Consultation Response from KC Landscape

Application No:	2024/90058
Proposed Development:	Reserved Matters application, including the considerations of appearance, scale, layout, and landscaping, for the erection of 67 dwellings, pursuant to outline permission 2020/92307 for the erection of residential development (up to 75 units) and the discharge of conditions 7 (include a Written Scheme of Archaeological Investigation (WSI) and Designer's Response), 8 (Foul and Surface Water Drainage Strategy), 9 (flood routing), 10 (mitigatory tree-planting), 11 (cycle parking), 12 (Arboriculture Assessment), 13 (Ecological Design Strategy), 14 (Bar survey), 15 (noise impact assessment)
Location:	Penistone Road/, Rowley Lane, Fenay Bridge, Huddersfield, HD8 0JS
Applicant/Agent:	Johnson Mowat
Planning Officer	Nick Hirst
Date Responded:	27.03.2024
Responding Officer:	EM
Responding Ref:	NN13

5.6 SITE LAYOUT AND DETAILED ANALYSIS

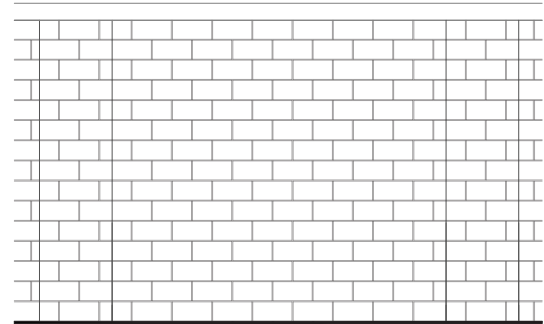
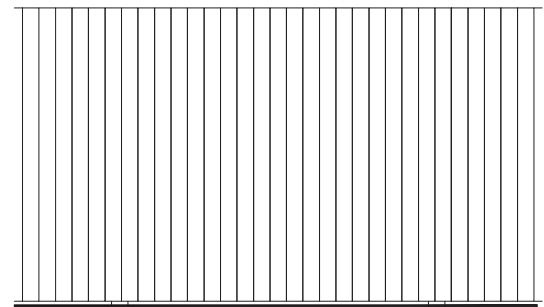
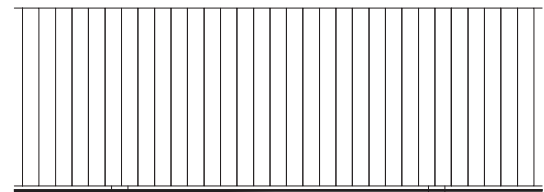
3. We welcome the open space and landscaping on site, and whilst much of the open space on site is well connected through the proposed footpath link, there are some areas indicated which do not constitute public open space, such as the visibility splays of the highways verges

at the entrance. Landscaped areas such as these are welcomed and important for a sense of arrival, however they are not POS.

7. In landscape design terms, the scheme ensures there is a clear definition of residential amenity and an appropriate defensible space for the dwellings. The open space is well overlooked, however, there appears to have been little thought yet as to the design of the public open spaces for the intended uses and users. The majority of the space allocated as public open space appears to be amenity greenspace, however, even then, there do not appear to be any seating areas for users of the public open spaces nor litter bins – **have these been discounted for some reason?**

Revision of landscaping plan to address comments raised above.
